RE: File # SP-07-118, Nelson Short Plat

TO: Mackenzie Moynihan, Community Development Services  
FROM: Christina Wollman, Planner II *cw*  
DATE: October 8, 2008  
SUBJECT: Nelson Short Plat SP-07-118

TO: Mackenzie Moynihan, Staff Planner, Community Development Services  
FROM: Randy Carbary, Planner II *rc*  
DATE: September 18, 2007  
SUBJECT: Nelson Short Plat

NELSON SHORT PLAT (SP-07-118)

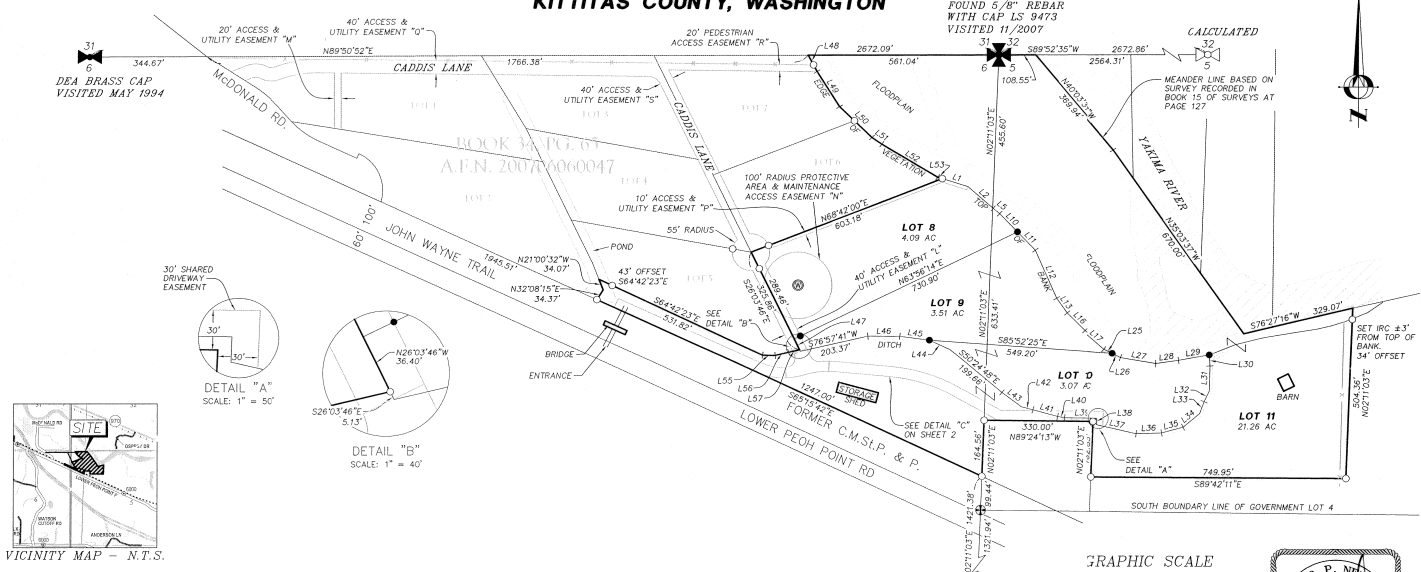
2. **Road Name:** Caddis Lane shall be identified on the final plat.
3. **Access:** All access to the lots shall be from Caddis Lane.
4. **Private Road Improvements:** Access from McDonald Road to the hammerhead shall be constructed to meet or exceed the requirements of a High-Density Private Road that serves 3-14 tax parcels. See Kittitas County Road Standards, 9/6/05 edition.

5. Hammerhead Turnaround: A hammerhead turnaround that meets the requirements of the International Fire Code shall be constructed at the end of Easement 'L' (Caddis Lane).

6. Lots 10 and 11 Access: Access from the hammerhead from to Lots 10 and 11 shall be constructed as a joint use driveway.

1. Vicinity Map: Kittitas County Code 16.12.020, G requires that existing features such as roads are shown. In order to clarify where access for the proposed lots originates from the vicinity map shall show the access to the proposed subdivision from Mc Donald Road.

2. Legal Description: The legal description, as it appears on the plat, seems to be correct as it contains the same information as the legal description provided in the Subdivision Guarantee. However, a portion of the description is not listed in the same order. The legal description on the plat should be revised to match the legal description provided in the Subdivision Guarantee.

3. Access to Lots 10 & 11 – Crossing Agreement: Access to lots 10 & 11 is being proposed via a 30' access and utility easement "T", as shown on the face of the plat. The easement appears to cross the John Wayne Trail. Permission is required from Washington State Parks for access across the John Wayne Trail. The applicant shall be responsible for providing proof of legal access prior to final plat approval.

4. Access to Lots 10 & 11 – Grade / Transition: It appears that the existing driveway that is being proposed as access to lots 10 and 11 does not meet the current Kittitas County's requirements for grade and transition from Lower Peoh Point Road. Before granting

8. Access to Lots 8 & 9: Access to these lots shall be constructed to meet or exceed the requirements of a High-Density Private Road serving 3 to 14 lots and serve no more than 14 tax parcels. See Kittitas County Road Standards, 9/6/05 edition.
